**Our Ref: BR/148/19/HH**  
**Your Ref:**

**Town & Country Planning Act 1990 (as amended)**  
**Town & Country Planning (Development Management Procedure) (England) Order 2015**  
**Application for Planning Permission for Works or Extension to a Dwelling**

**Development**     Single storey rear extension  
**Location**        25 Ash Grove Bognor Regis

Block Plan

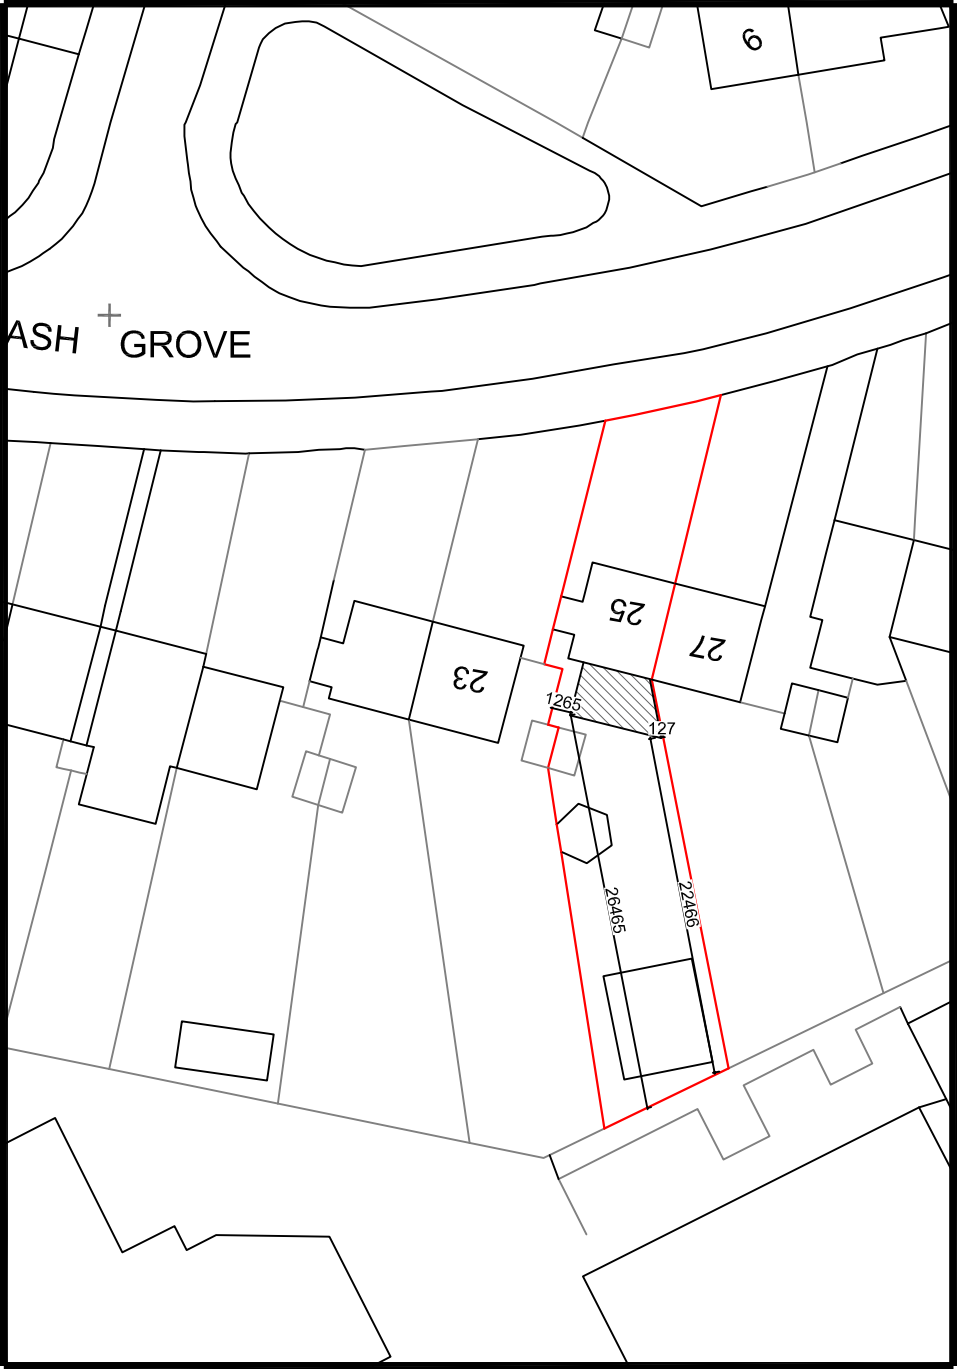
Block Plan

Please submit 1 electronic or 3 paper copies of a block/site plan at a scale of 1:500 or 1:200. Please ensure all dimensions from the proposed extension to the site boundaries are included. Further details of what must be included on the plan can be found in the National Validation Requirements.
